**ADC Planning Consultation
Response from the Historic Buildings Adviser**

Application Number	AB/17/15/L
Address	61 Maltravers Street, Arundel
Description	Application for Listed Building Consent for internal alterations and new window.
Case Officer	Anita Gardner
Site Visit	21 January 2015

PROPOSED 1ST FLOOR PLAN
(SCALE 1:100)

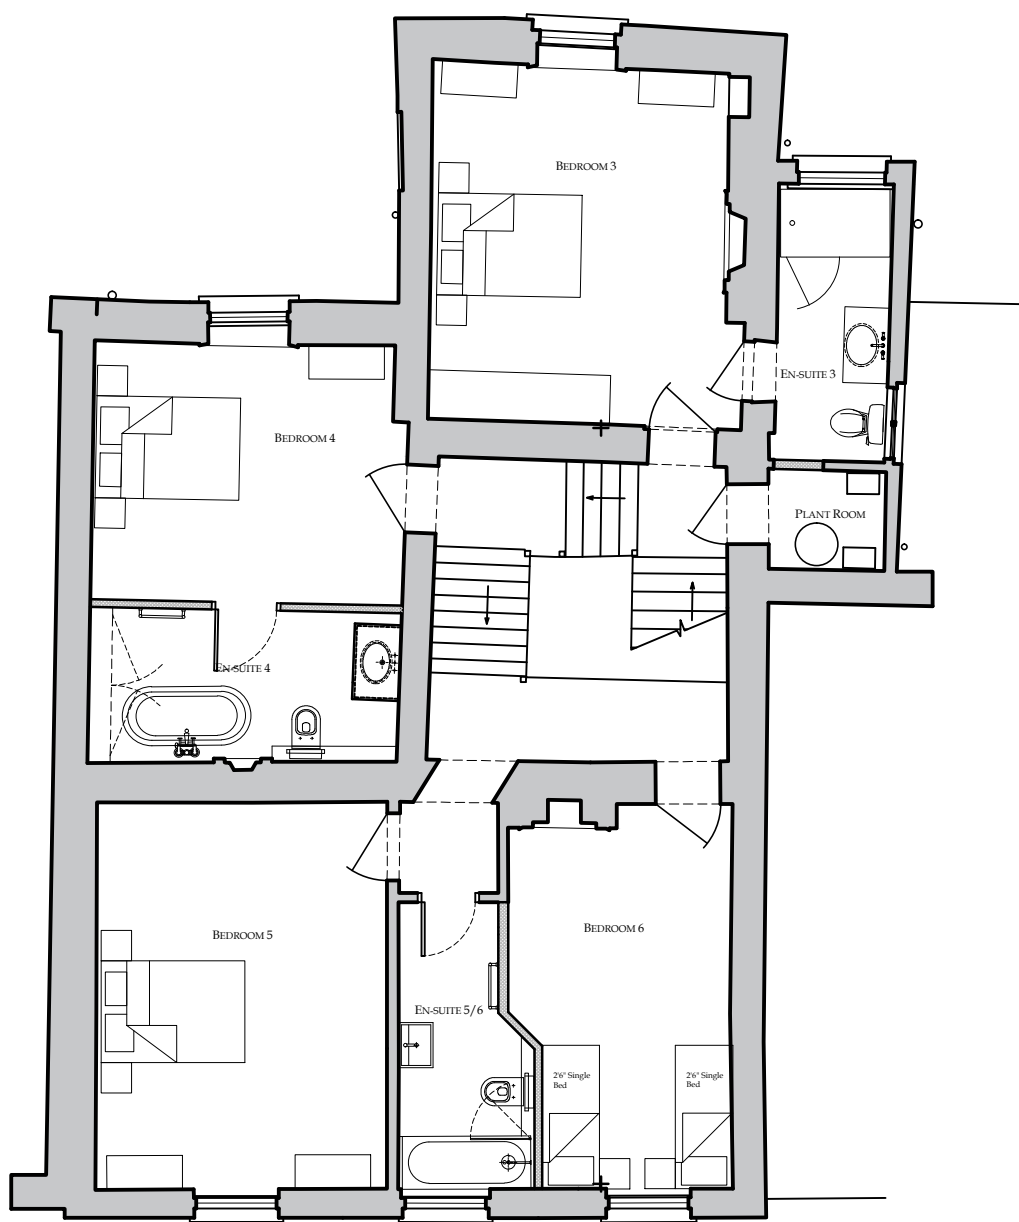
This scheme is generally acceptable and as discussed and agreed on site. An exception, are the built-in cupboards in the proposed 'master suite' which should be retained. These appear to be historic and contribute to the character of the room. The historic doors to be blocked in should also be retained and sealed shut. These could remain visible from the corridor. Please condition.

Elsewhere, the main alterations are the sub-division of rooms to provide en-suites. Whilst this is not ideal, the proposals should at least allow for reversibility and to this end it is important that existing details such as coving and skirting are not harmed by the installation of new stud walls. Please condition sections where new walls could affect plasterwork as well as details of new timberworks – skirting; doors etc.

PROPOSED BASEMENT PLAN
(SCALE 1:100)

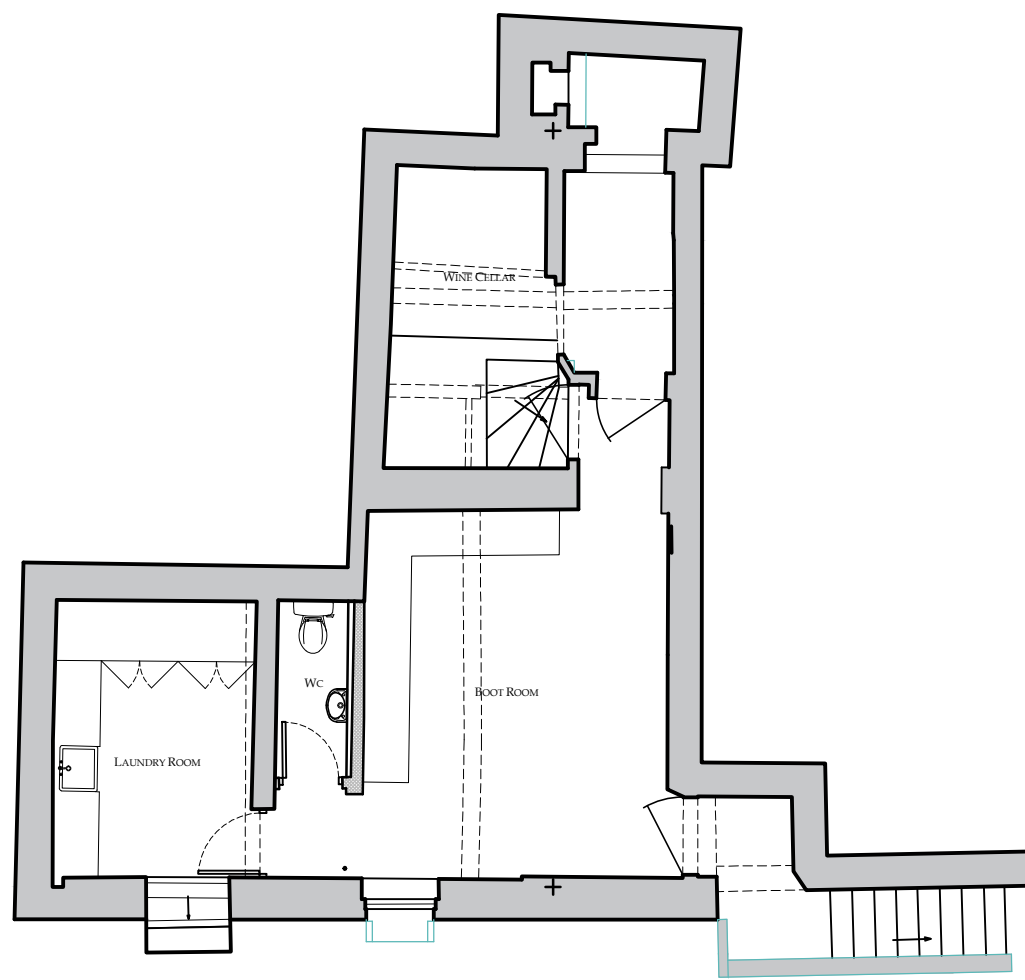
The partition in the basement was due to be retained as discussed, however its removal is not particularly problematic.
